Development Facilitation Team (DFT) – Review Comments

Project No: PR-2018-001681 Date: 06/28/2023 Agenda Item: #1 Zone Atlas Page: L-9

Application For: SD-2023-00106 - PRELIMINARY PLAT (DHO)

DRB Project Number: 2018-001681 (1003449)
Sunset Gardens and 86th

SITE PLAN

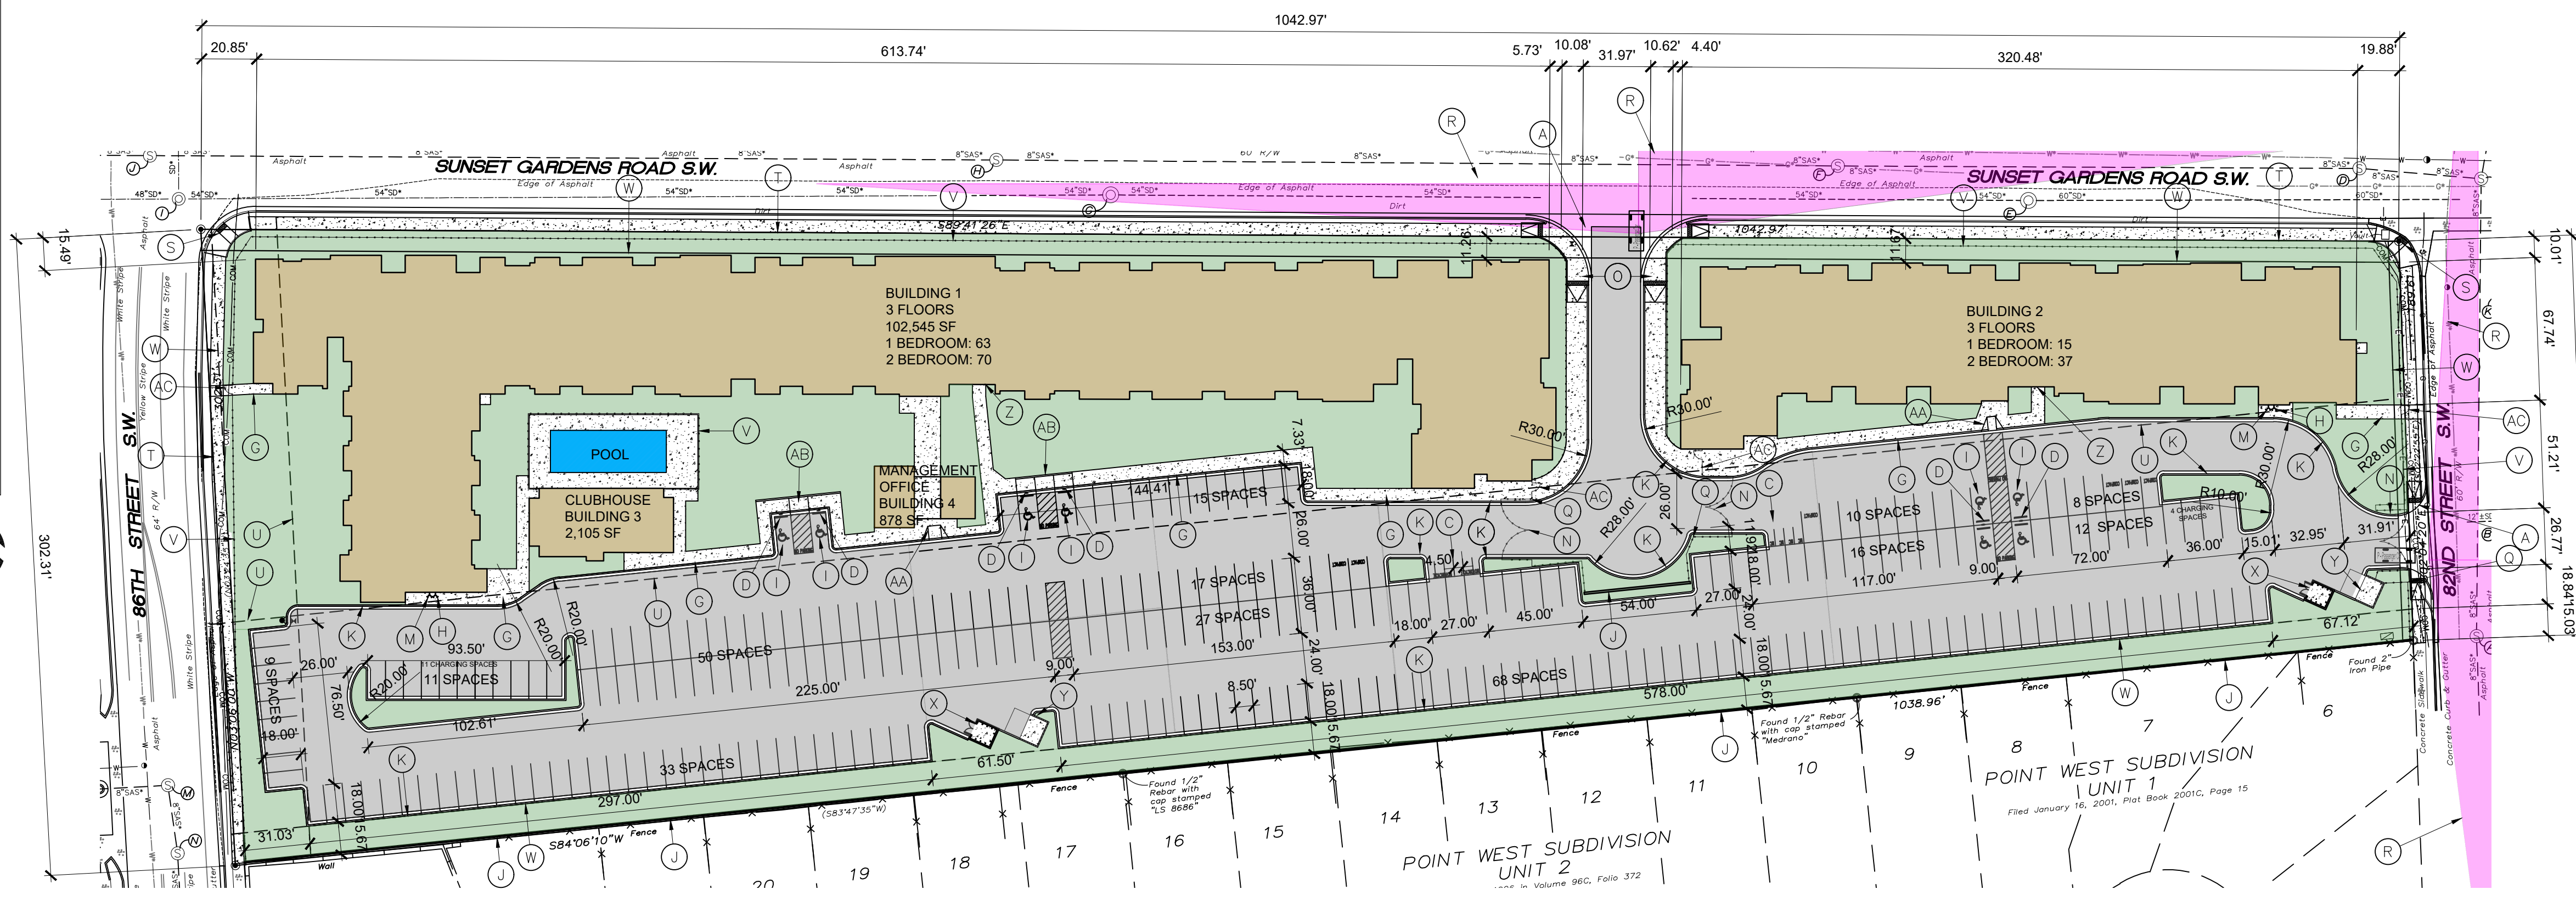
1. Transportation has an approved Conceptual TCL dated 1/24/2023. As a reminder a full TCL will be required prior to building permit.
2. All adjacent streets show required curb, gutter and sidewalk, but it also shows landscape buffers at 86th St. at 4' where as a Major collector 5-6' is required and for Sunset Gardens and 82nd at 2' and 3' respectfully where as local roads they require 4-6'. Please provide required buffer or a justification as to allowing the smaller width.
